# Comhairle Contae Chill Mhantáin Wicklow County Council

**RE: PROPOSED PLANNING APPLICATION FOR DEVELOPMENT OF 426 RESIDENTIAL UNITS AT  
FARRANKELLY, GREYSTONES, CO. WICKLOW.**

First Floor Plan

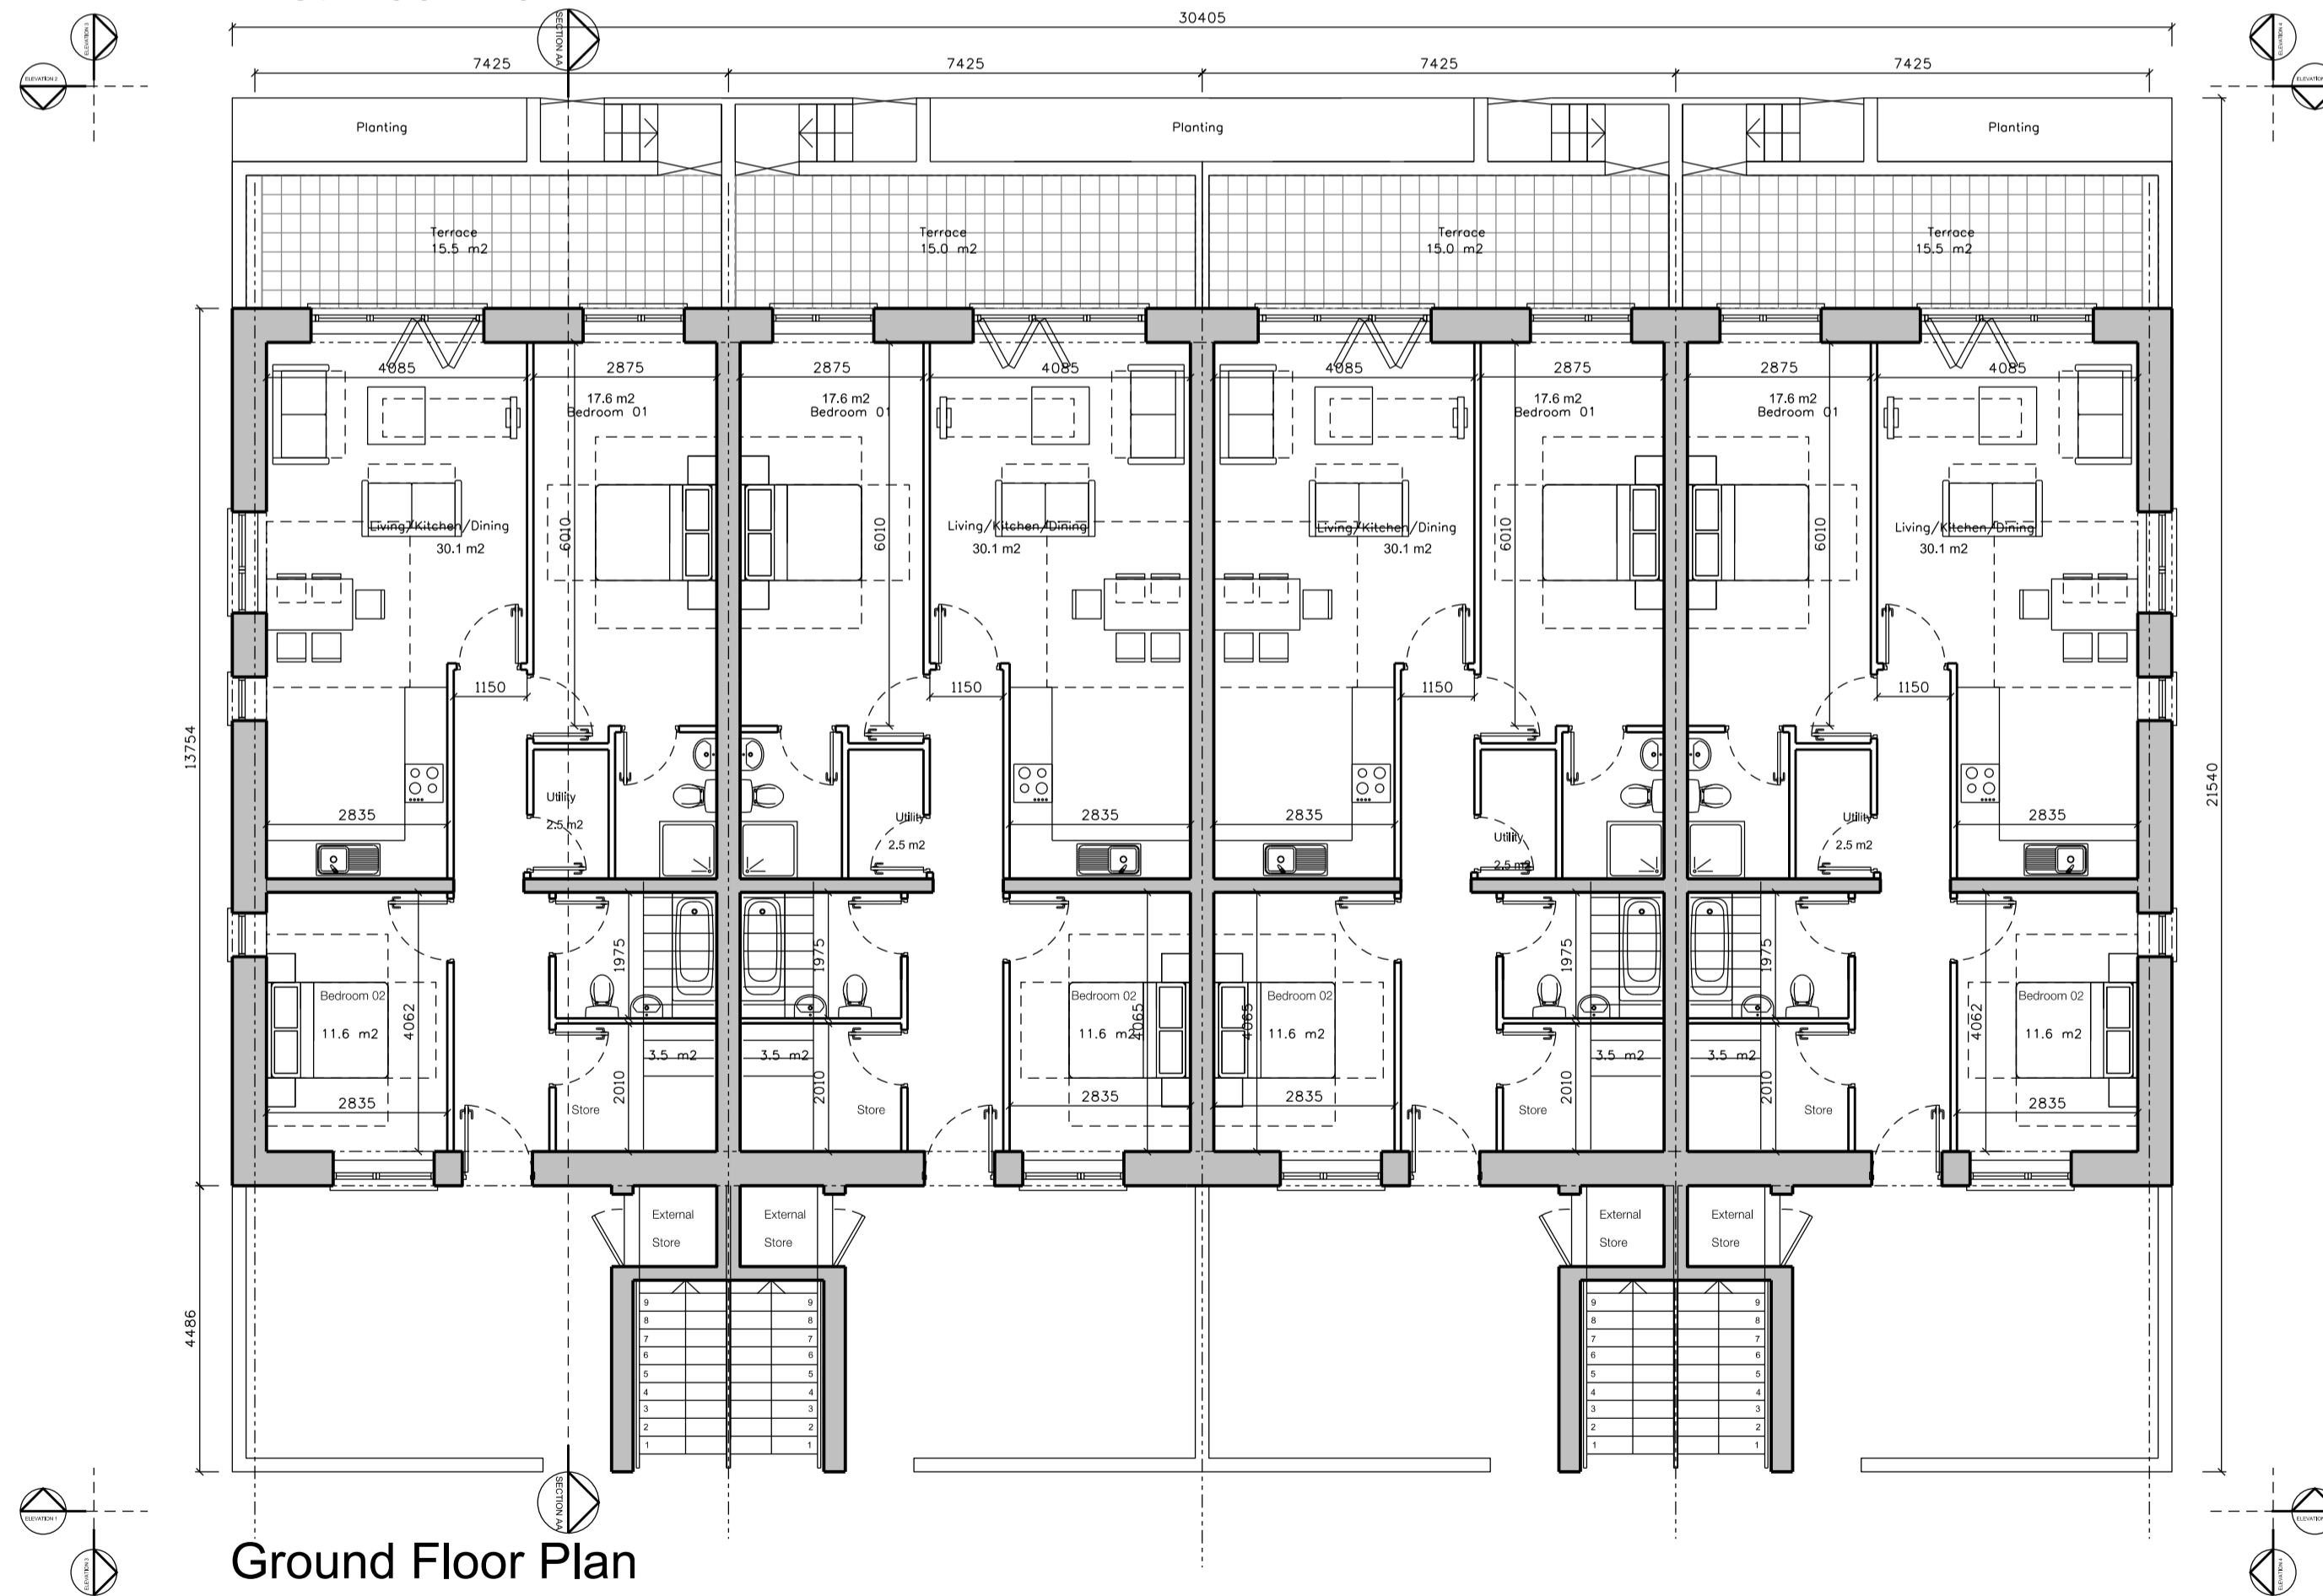
- 3 no. 3 x bed 5 person town houses type B2. The units are oversized at 114.5sqm the current target is 101sqm. The en-suites are not required.
- 4 no. 2 x bed duplex ground floor apartments. The units are oversized at 89.5sqm the current target area is 80sqm.
- 4 no. 3 x bed duplex 2 storey apartments. The units are oversized at 121sqm and the target area is 101sqm. En-suites should be removed if possible.
- 19 no. 2 bed apartments. The units appear to be oversized at 85/86sqm. The target area for a 4 person 2 bed apartment is 80sqm. En-suites should be removed if possible.
- 12 no. 1 bed apartments. The 1 x bed apartments appear to be marginally oversized at 51sqm and the target area is 50sqm but may be acceptable.
- All of the apartments have shared entrances – the Council's preference is for own door units.
